## **Submissions of Ms Fiona Cramb at Deadline 13**

EA1N 20023282

EA2 20023287

**Figure: 29.37f**  
**Viewpoint 5: Public Right of Way, near Moor Farm**

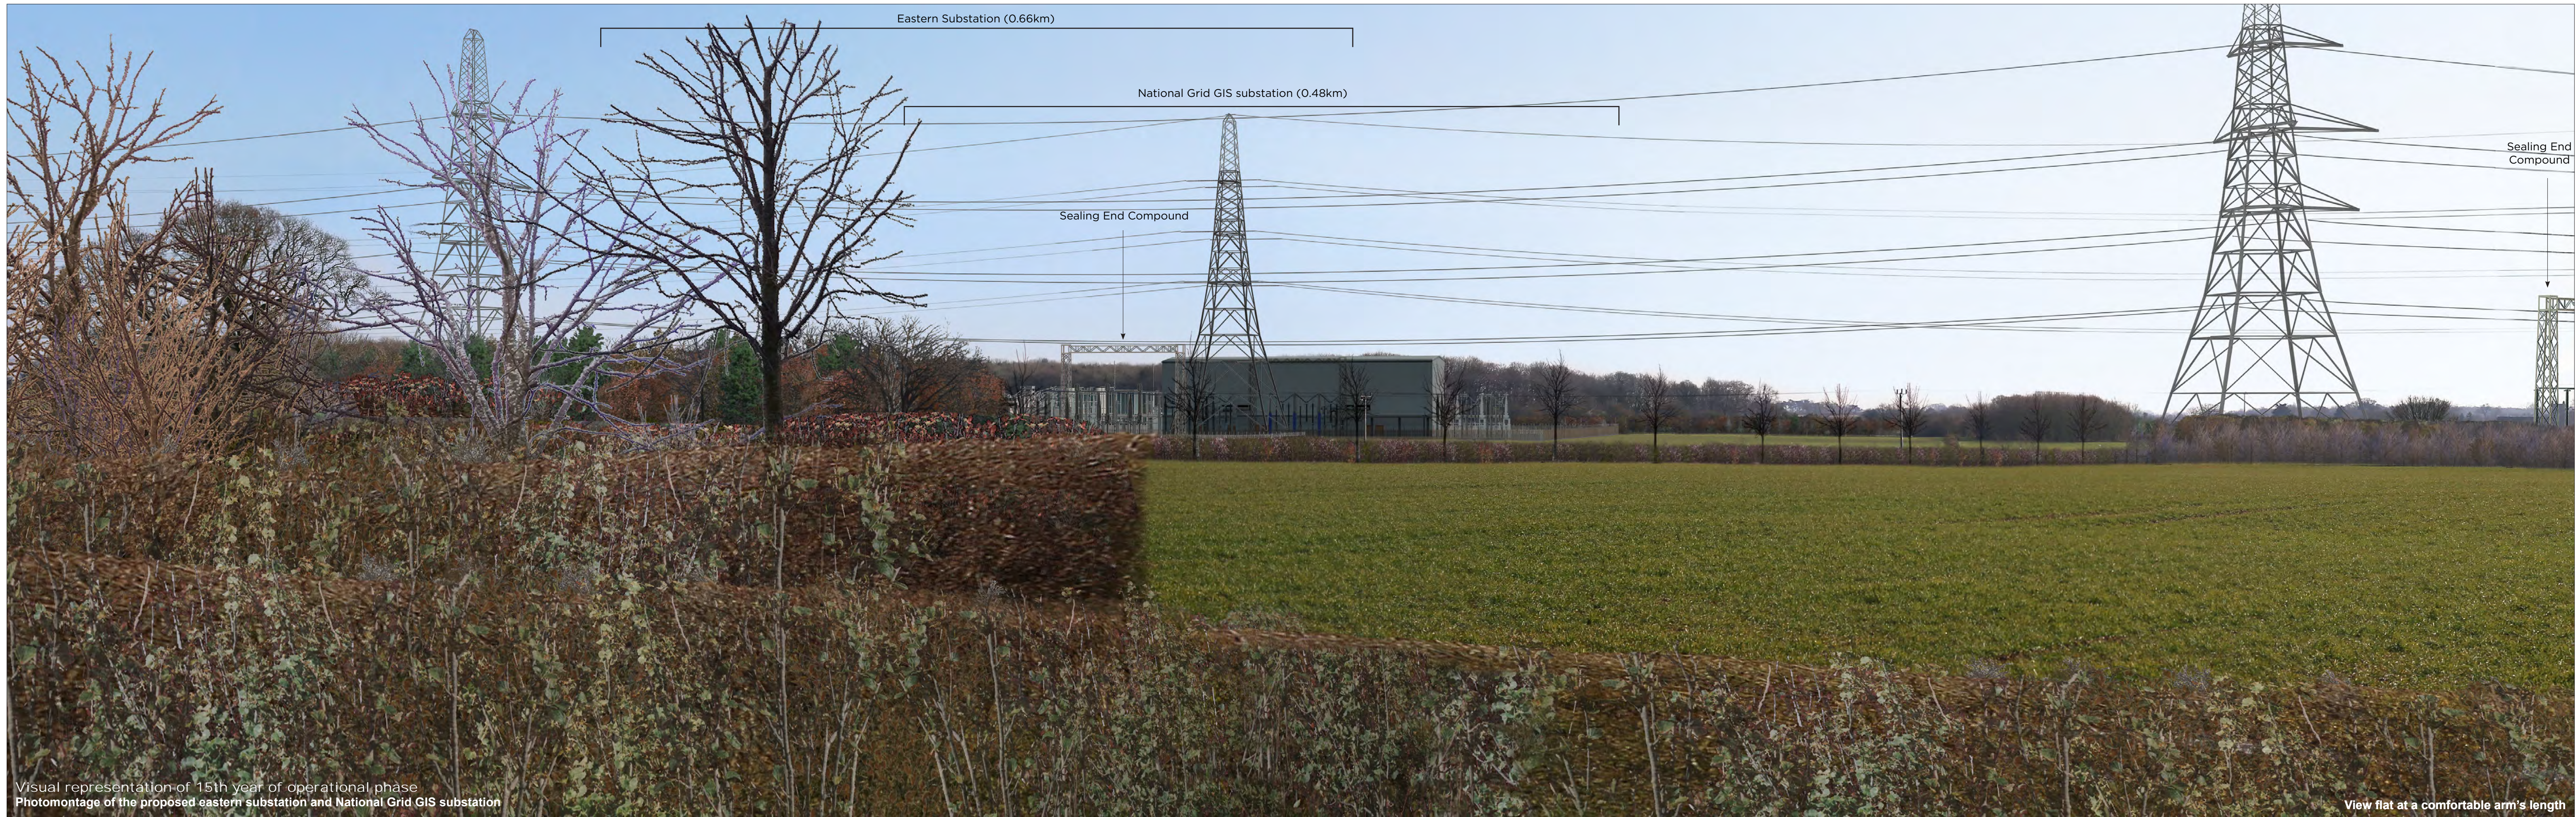
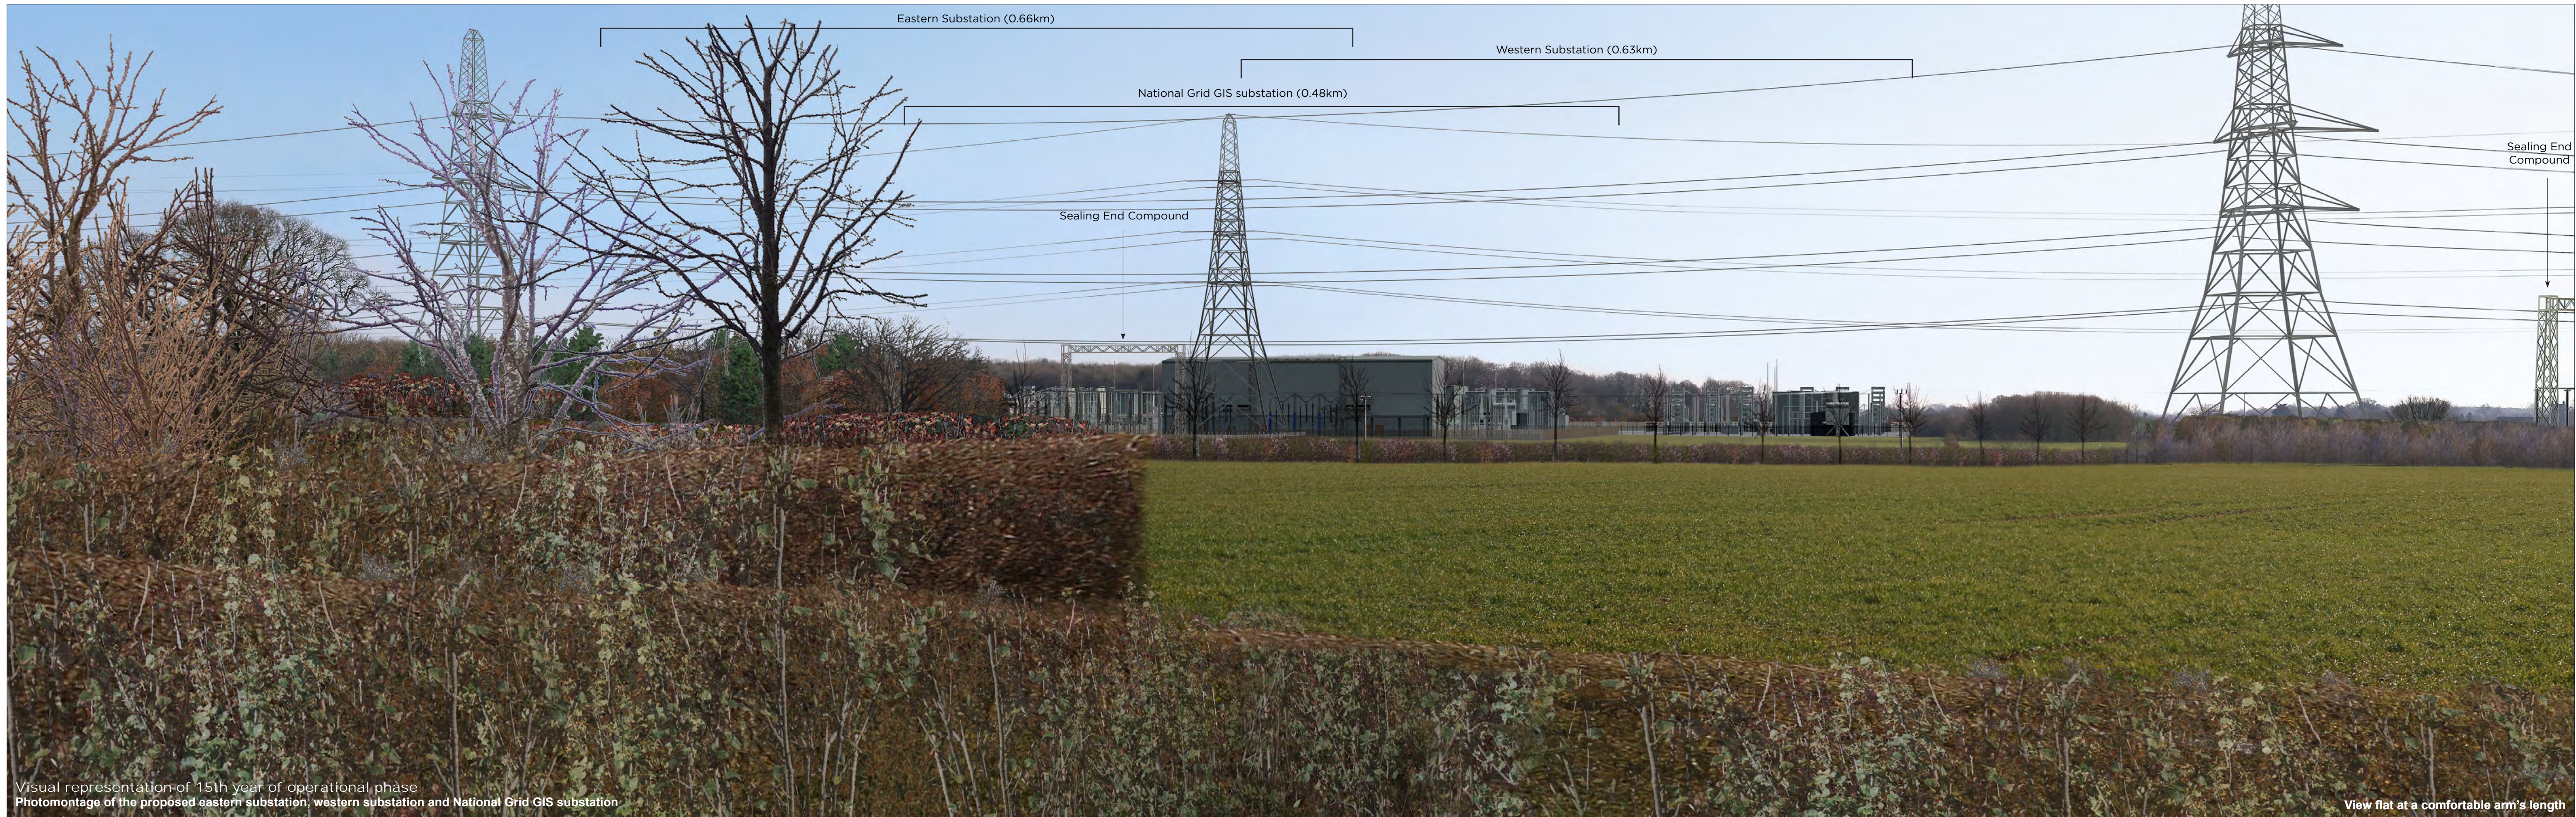
8. The applicant persists in using Viewpoint 5 to illustrate its comments. As has been pointed out to them numerous times this viewpoint does not represent the view from High House Farm and the impact of the development upon us. In the Applicants’ Responses to Examining Authority’s Written Questions 3 Volume 7 – 3.10 Landscape and Visual Impact 3.10.2. The photograph they have used is taken from just about the most obscure and misleading point possible. SPR then uses this to support its claim that: "The Applicant noted a mature vegetated boundary to the south-west of the property near Landscape Visual Impact Assessment (LVIA) Viewpoint 5 during its site survey work in the area in February 2019 (see photo below), which it considered would provide some screening and a basis from which to justify further planting

around this boundary.” This is absolutely ridiculous. It is taken from Viewpoint 5 at the corner of our property, towards the house. Taking that view from the house misses the substation site completely. It is the views from the house towards the village that are relevant.

“In ExA question 3.10.2 they identify that ‘the garden of High House Farm provided clear views across a largely open landscape to the Church of St Mary.’ VP 5 shows a similar open view across to the church as that from High House Farm. In response to ExA question 3.10.2, SPR’s justification for enclosing this view by planting appears to be that ‘The Applicants recognise that this will have to balance various interests.’ It is unclear how ‘consultation with local residents ... to discuss their expectations for landscape work in the vicinity of their properties’ can address this issue satisfactorily.”
